CITY OF ALBUQUERQUE

**RE: Cuesta Arriba Warehouse
1320 Cuesta Arriba Ct NE
Temporary Certificate of Occupancy
Engineer's Certification Date: 9/30/2025
Engineer's Stamp Date: 07/21/23
Hydrology File: D16D104
Case # HYDR-2025-00350**

Sheet No.  
**C-101**

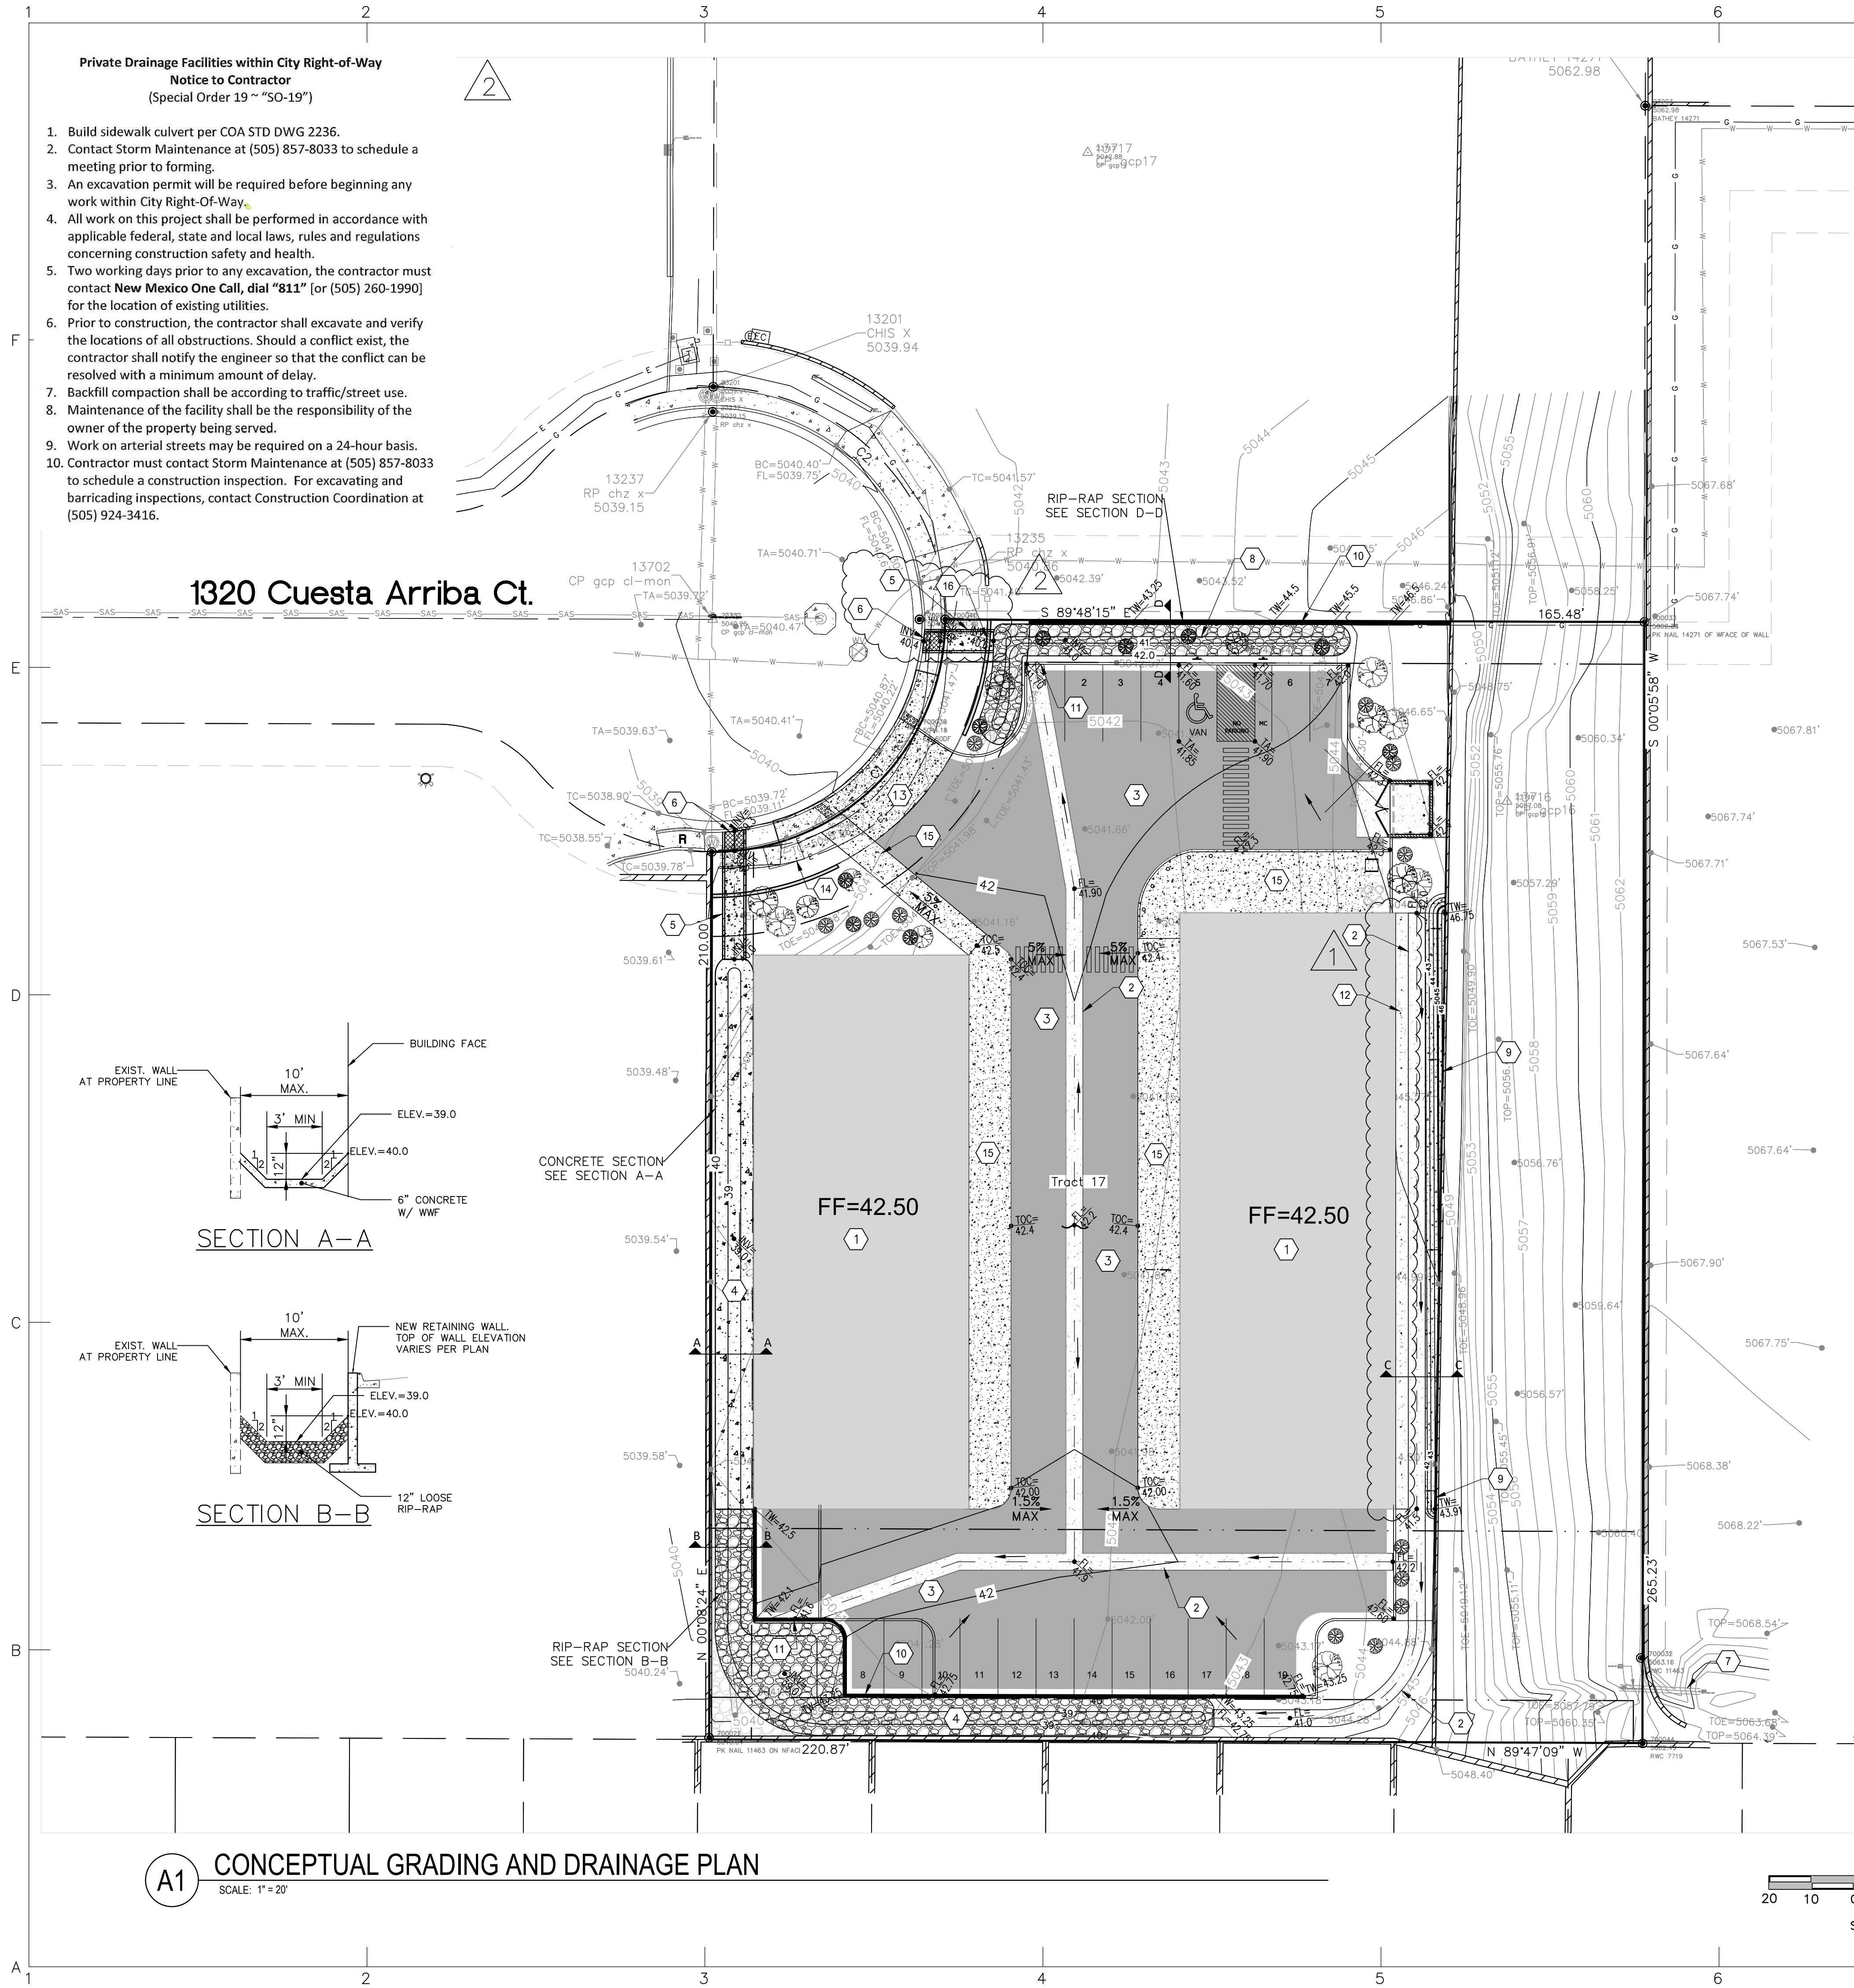
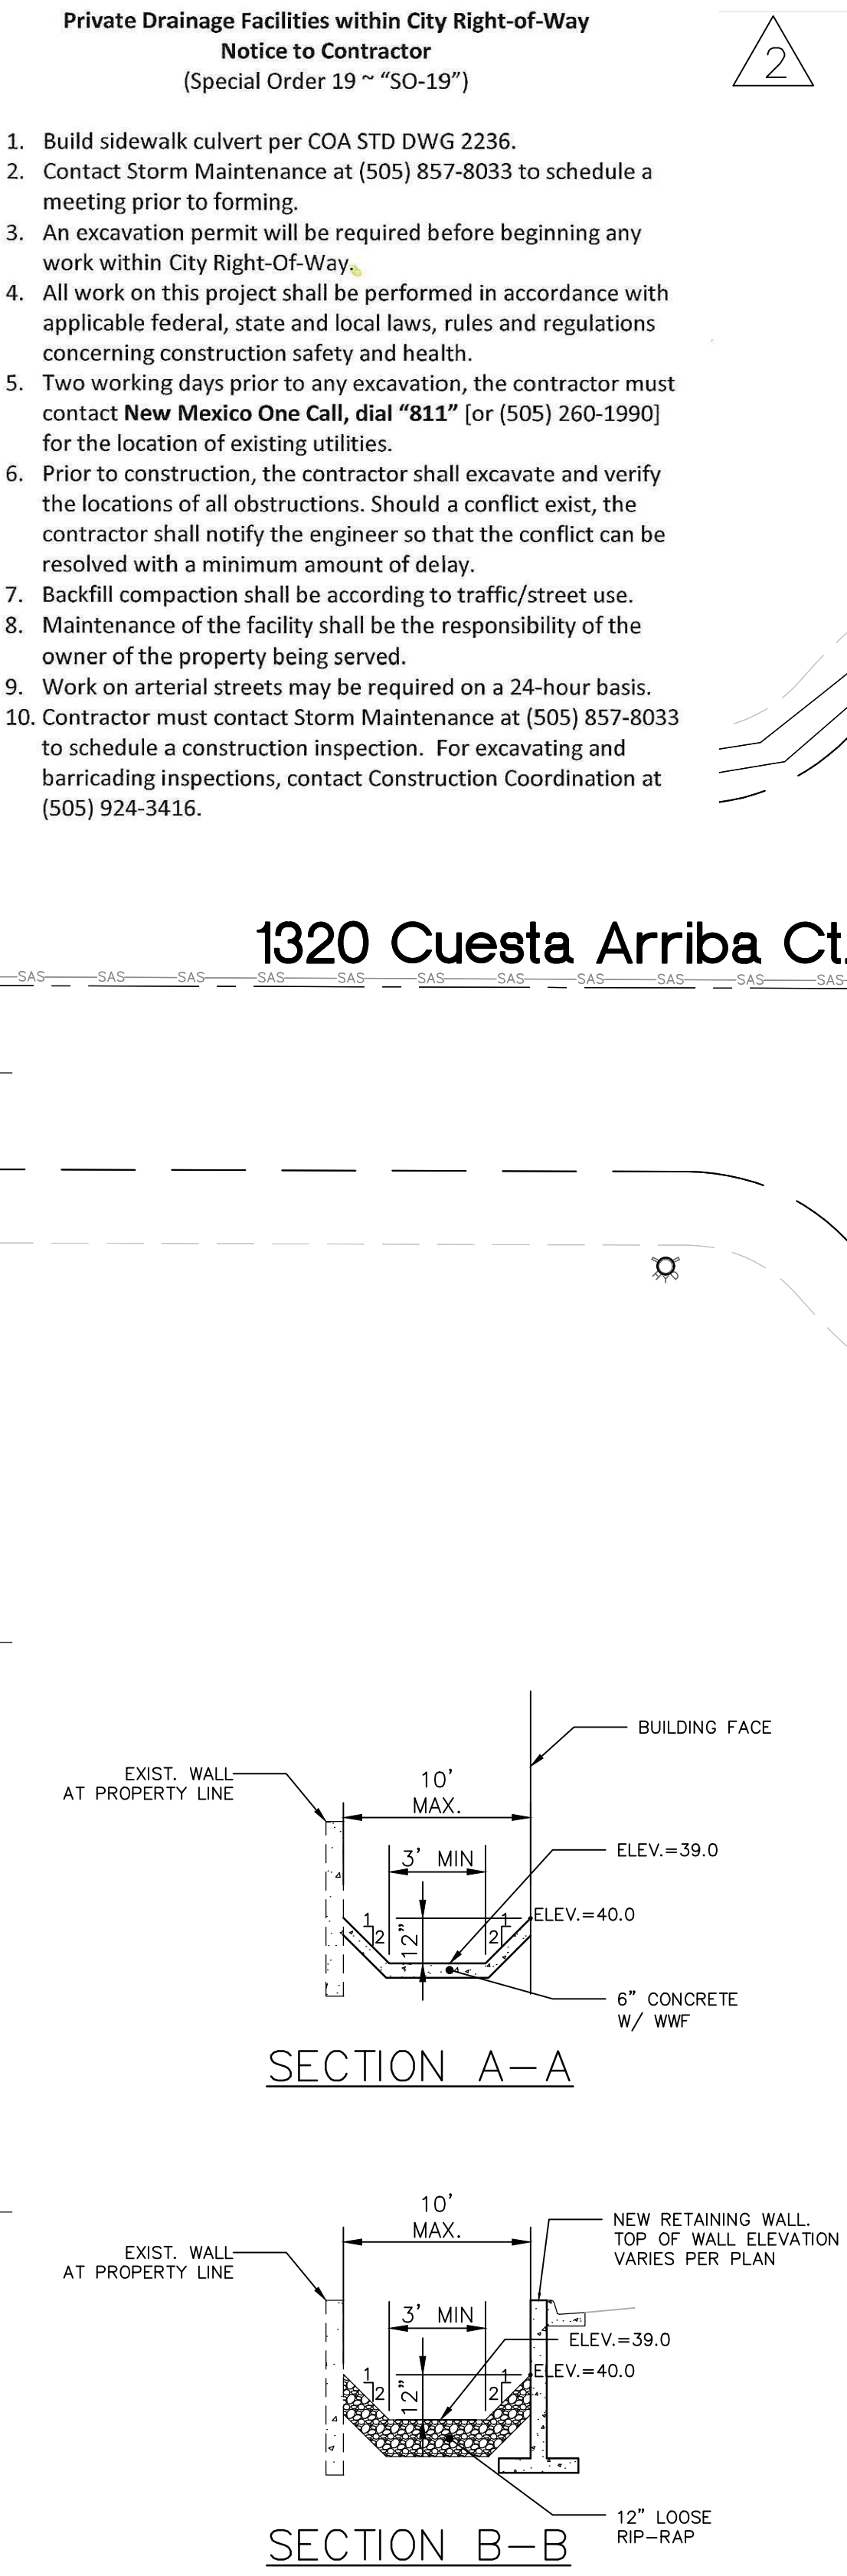
1. Please provide the Drainage Covenant with Exhibit A for the stormwater quality ponds per Article 6-15(C) of the DPM prior to Permanent Release of Occupancy. Please submit the original copies along with the **\$ 25.00** recording fee check made payable to Bernalillo County to Hydrology. Apply for a Covenant in the ABQ-PLAN system. Upload the Drainage Covenant and Exhibit A as attachments.
2. Complete the construction of the sidewalk culverts along the frontage per the approved plan.
